Application for a Non-Material Amendment Following a Grant of Planning Permission

Erection of 2 No. single storey rear extensions

PL/2023/01316/MINFHO

Amendment of external facade material

Proposed Elevations

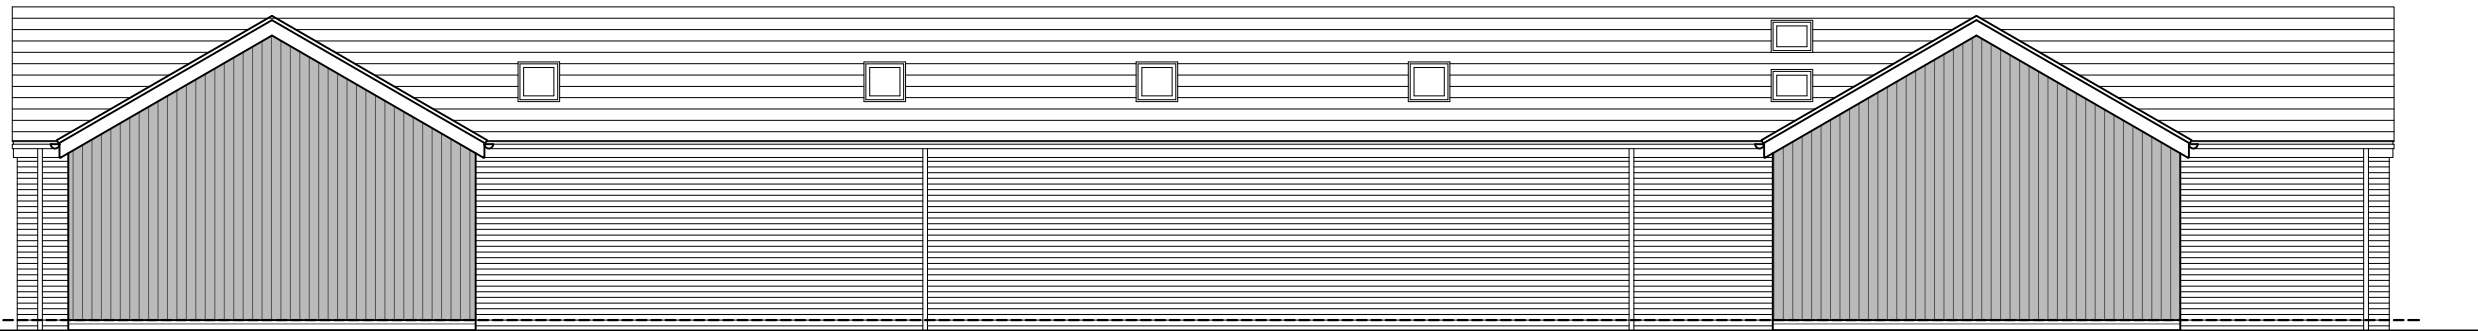
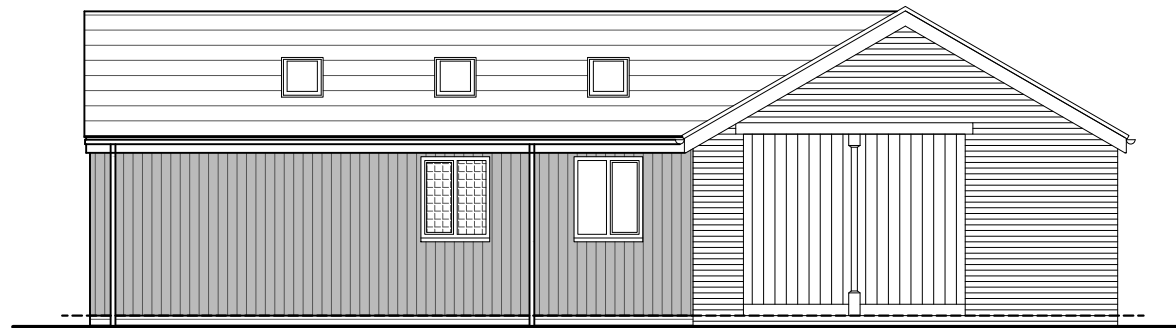
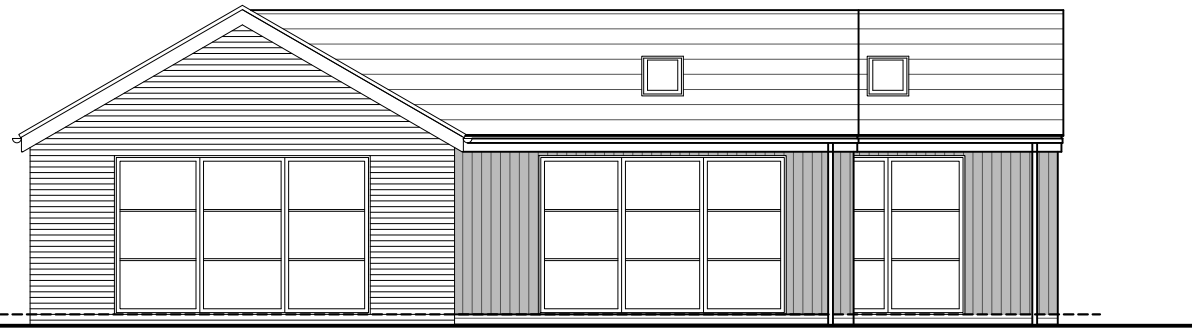
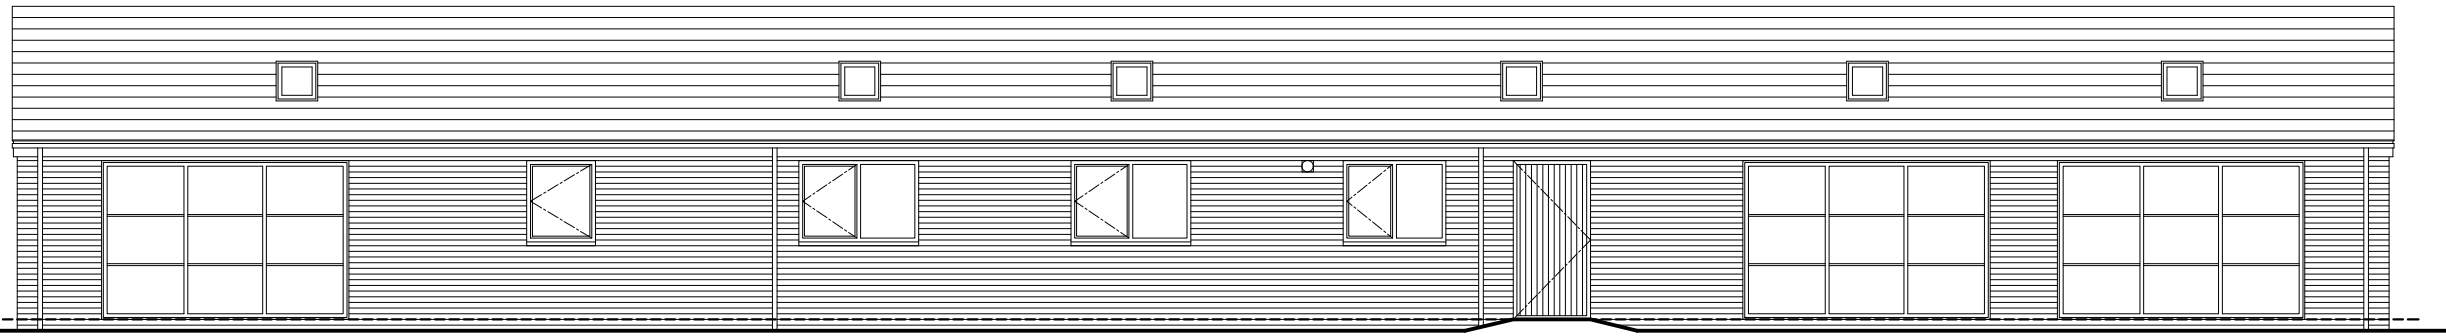
Applicant preference to amend to charred timber cladding

23010_300(B) - Proposed Elevations
23010_301(B) - Proposed Elevations
